DRB Project Number: 2021-006261
1860 Griegos

SUBJECT: Final Plat

Project Number: PR-2021-006261

Project Name: Griegos Farms

LP101

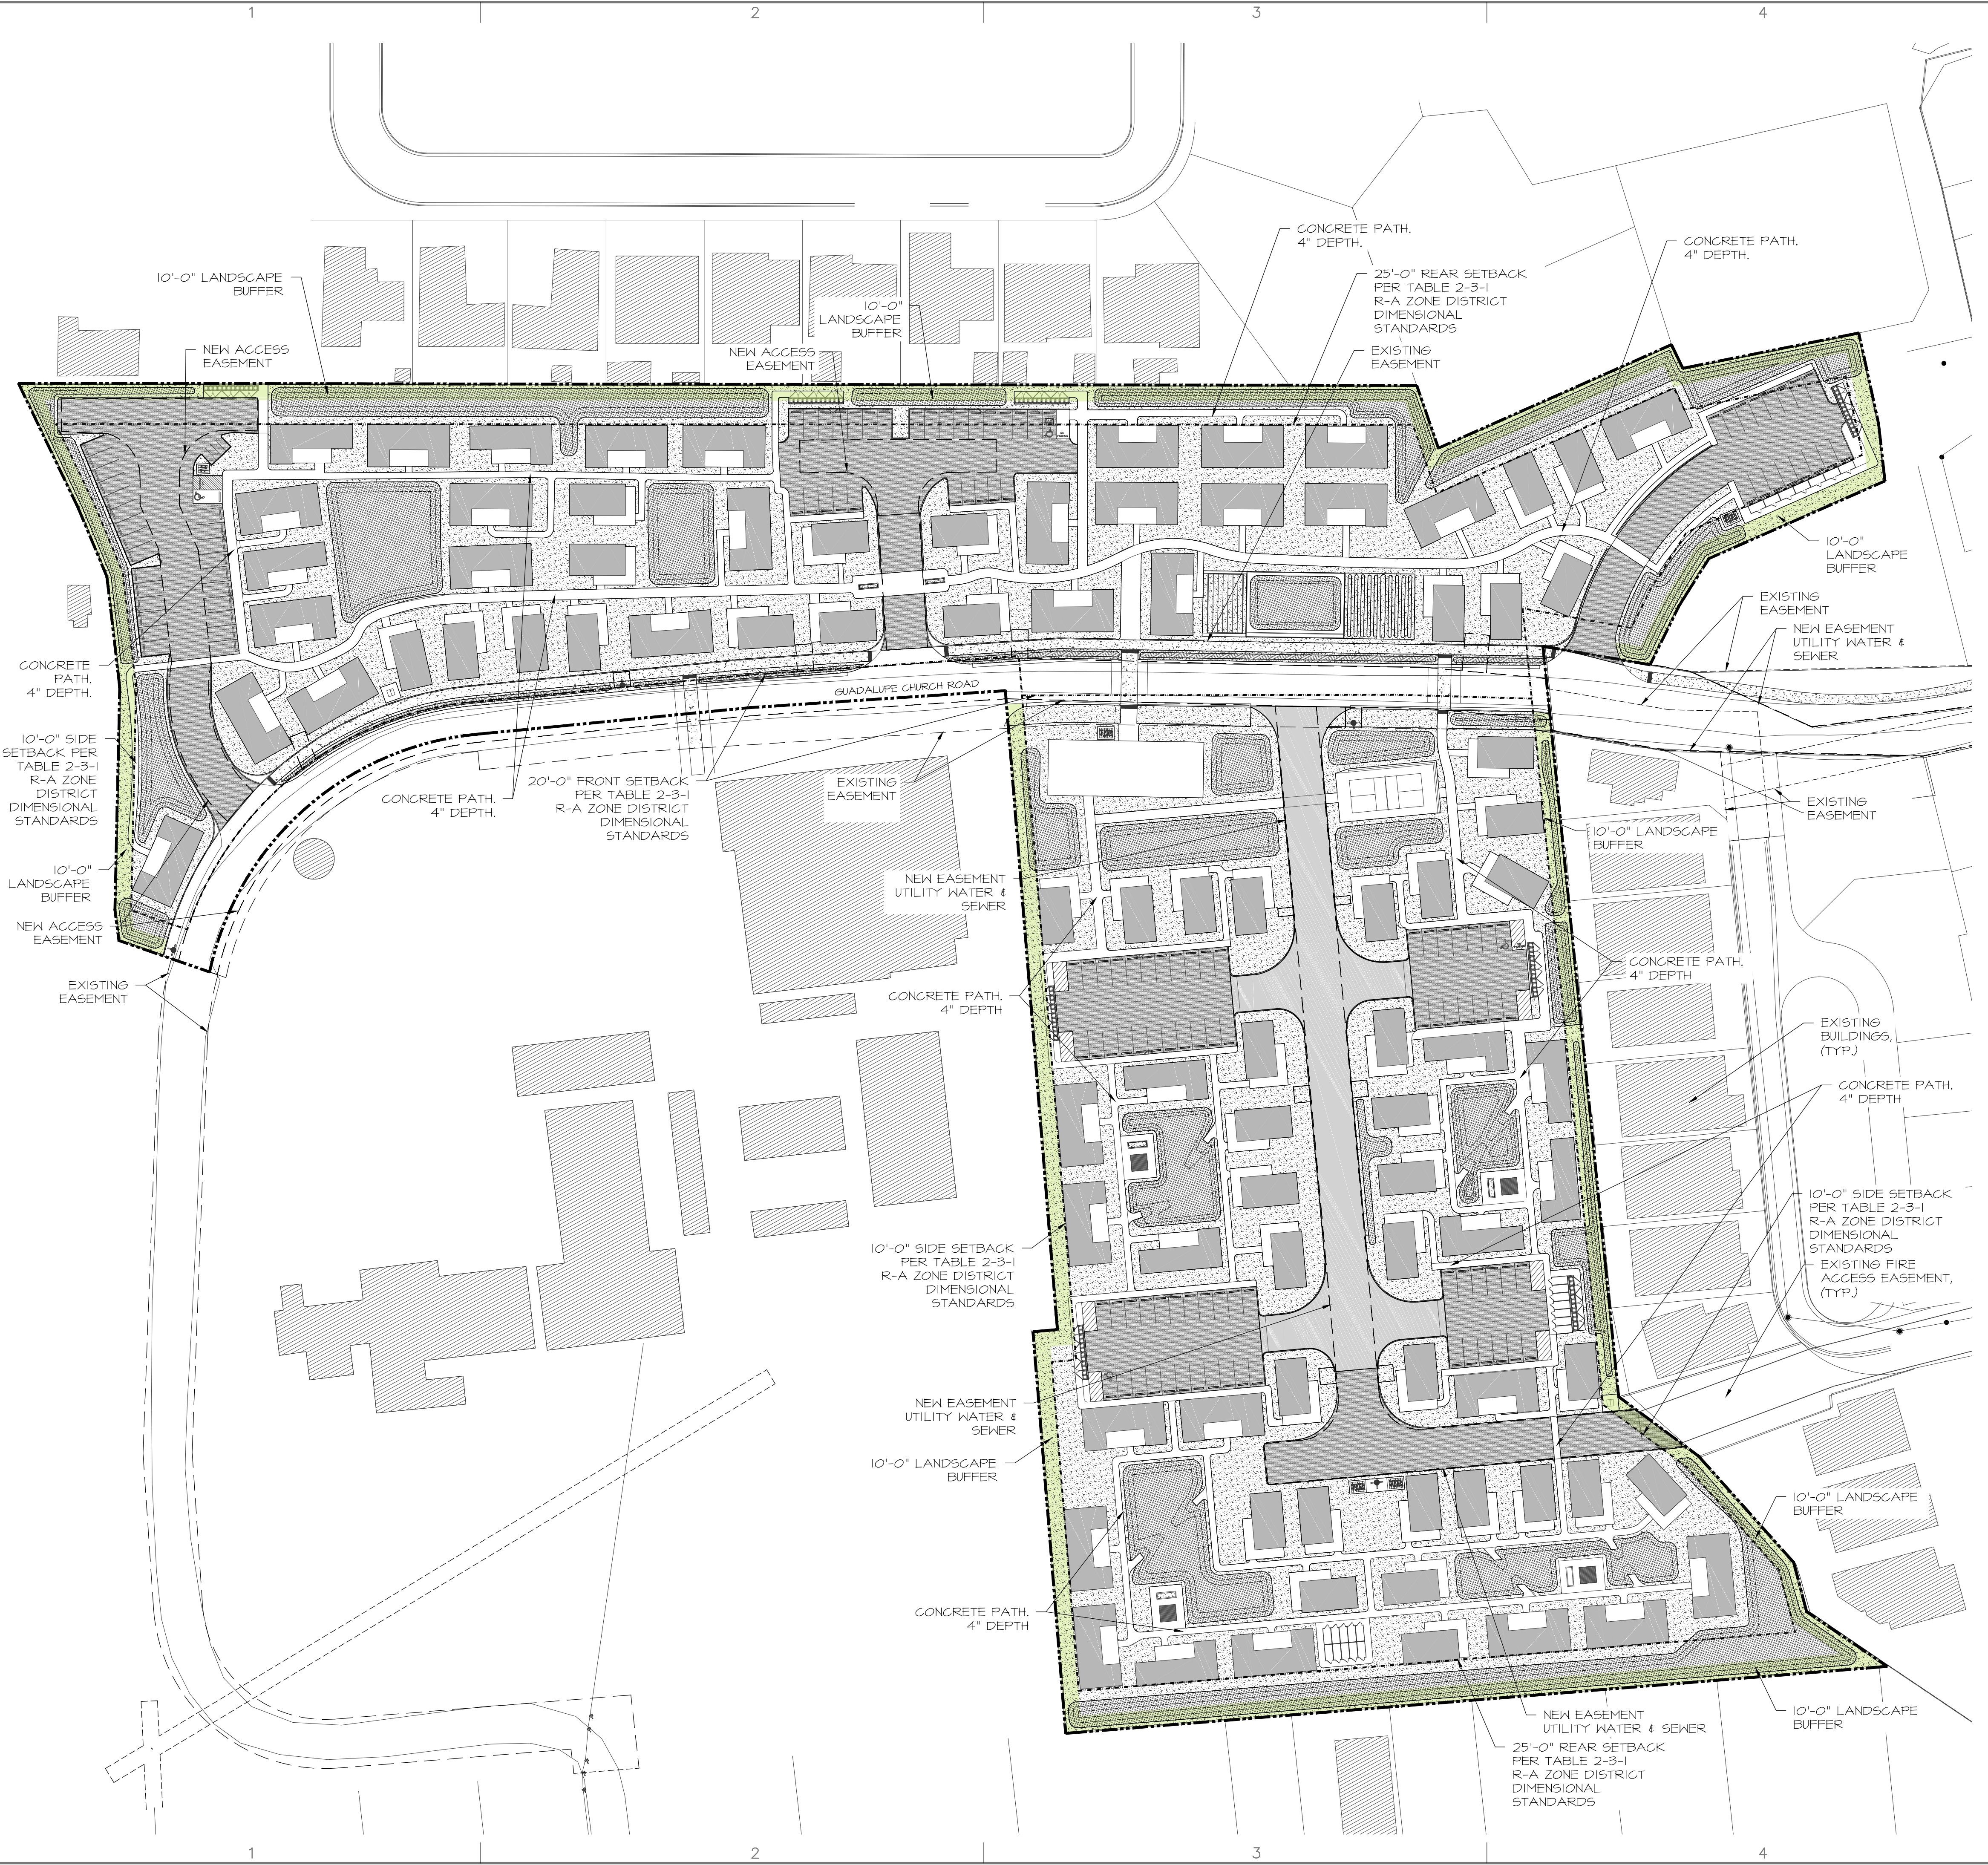
Staff Response: The project site has a 10-foot buffer or greater along each side and rear lot line. Please confirm that the all the landscape buffers are landscaping.

Please confirm how this 30 % usable open space requirement is being met. The landscape plan shows 126,636 s. f. of landscape area. The landscape area can count as usable open space as can the areas highlighted in yellow below.
